From: [REDACTED]
Sent: 10 April 2022 17:46
To: Planning
Subject: Planning Application 3/2022/0136 - Back Brennand Street
Attachments: IMG_3293.jpg

However, in terms of the current proposed plans I do have two significant concerns regarding the proposal to change the existing roofline on the north elevation which incorporates a raised flat roof within the existing pitched roof structure. My concerns about this aspect of the plans are as follows:

1 **North Elevation**
Scale: 1:100

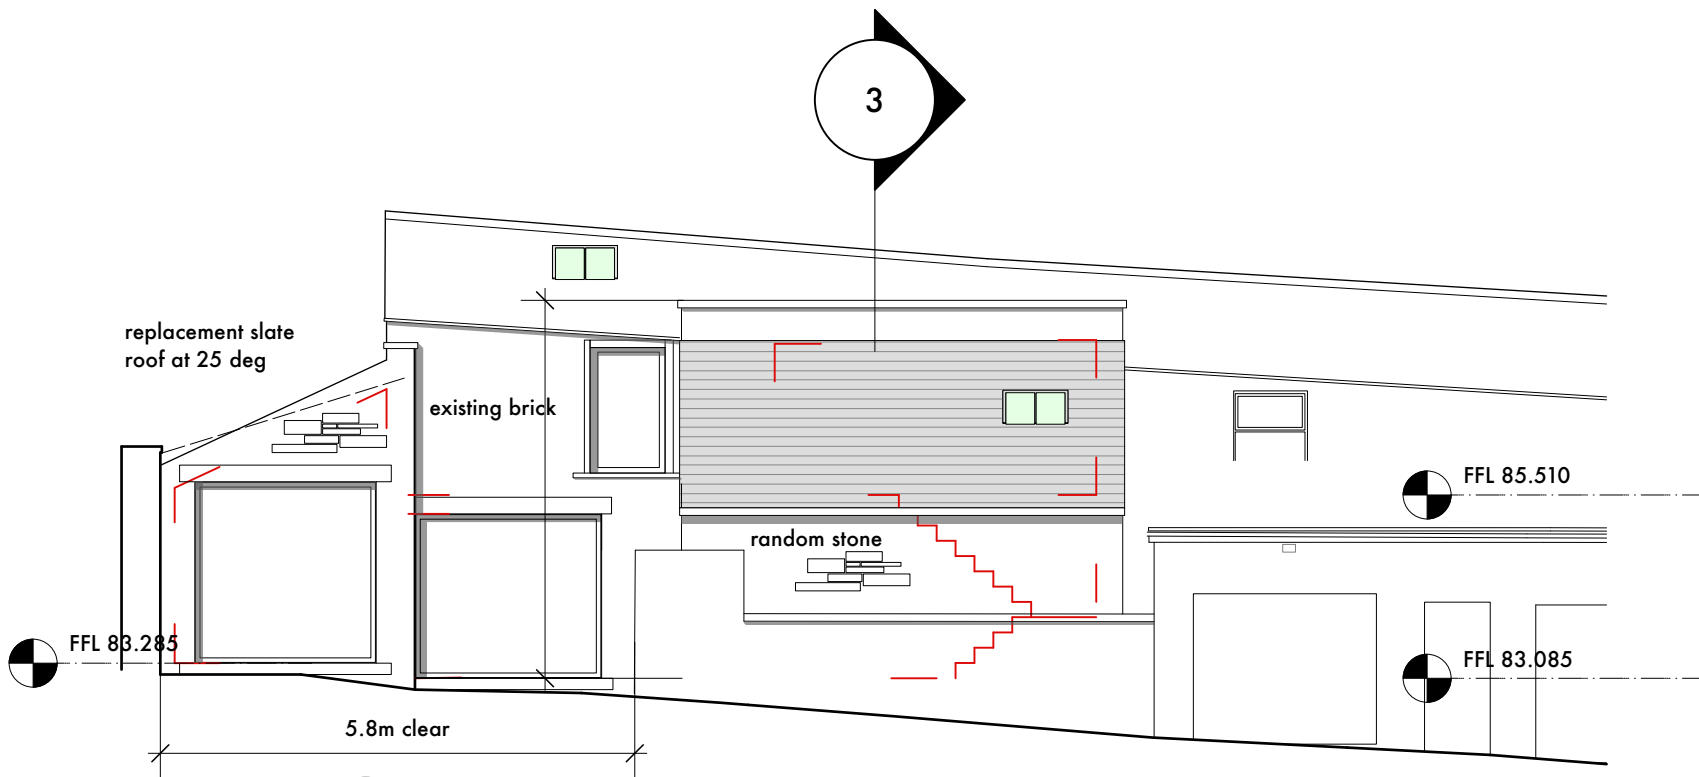
1. The proposed plans will have a significant, negative visual impact on the roofline of the existing buildings, particularly when approached from the Church Close end of the street. This goes against the stated objectives of conserving the character and appearance of a designated conservation area.

2. The building which is the subject of the planning application and the adjacent B K Cowperthwaite building were constructed at the same time and as a single structure. As such there is no clear point on the external walls where the first building ends and the second building starts, the two buildings share an internal upper dividing wall (which may well be of single brick construction) and there is a contiguous run of slates on the roof which services both buildings. I believe that the proposal to create a raised flat roof structure at the junction between the two buildings will compromise the integrity of the roof structure in this area and will lead to future water ingress issues for both properties. Whilst there has been some sagging to the existing roof timbers adjacent to the internal upper dividing wall, this has not resulted in any current or historic issue with water ingress at the roof level on the B K Cowperthwaite building and in many respects the sagging of the roof timbers adds to the character and appearance of the buildings.

I believe that the inclusion of the raised flat roof is mainly required because the proposed entry to the upper floor flat is situated at the lowest point of the eaves to the western end of the north elevation of the building. If the access to the upper floor flat was moved to the highest point of the eaves on the eastern end of the north elevation, or on to the eastern elevation itself, then the existing roofline would be maintained and both of the issues raised above would be resolved.
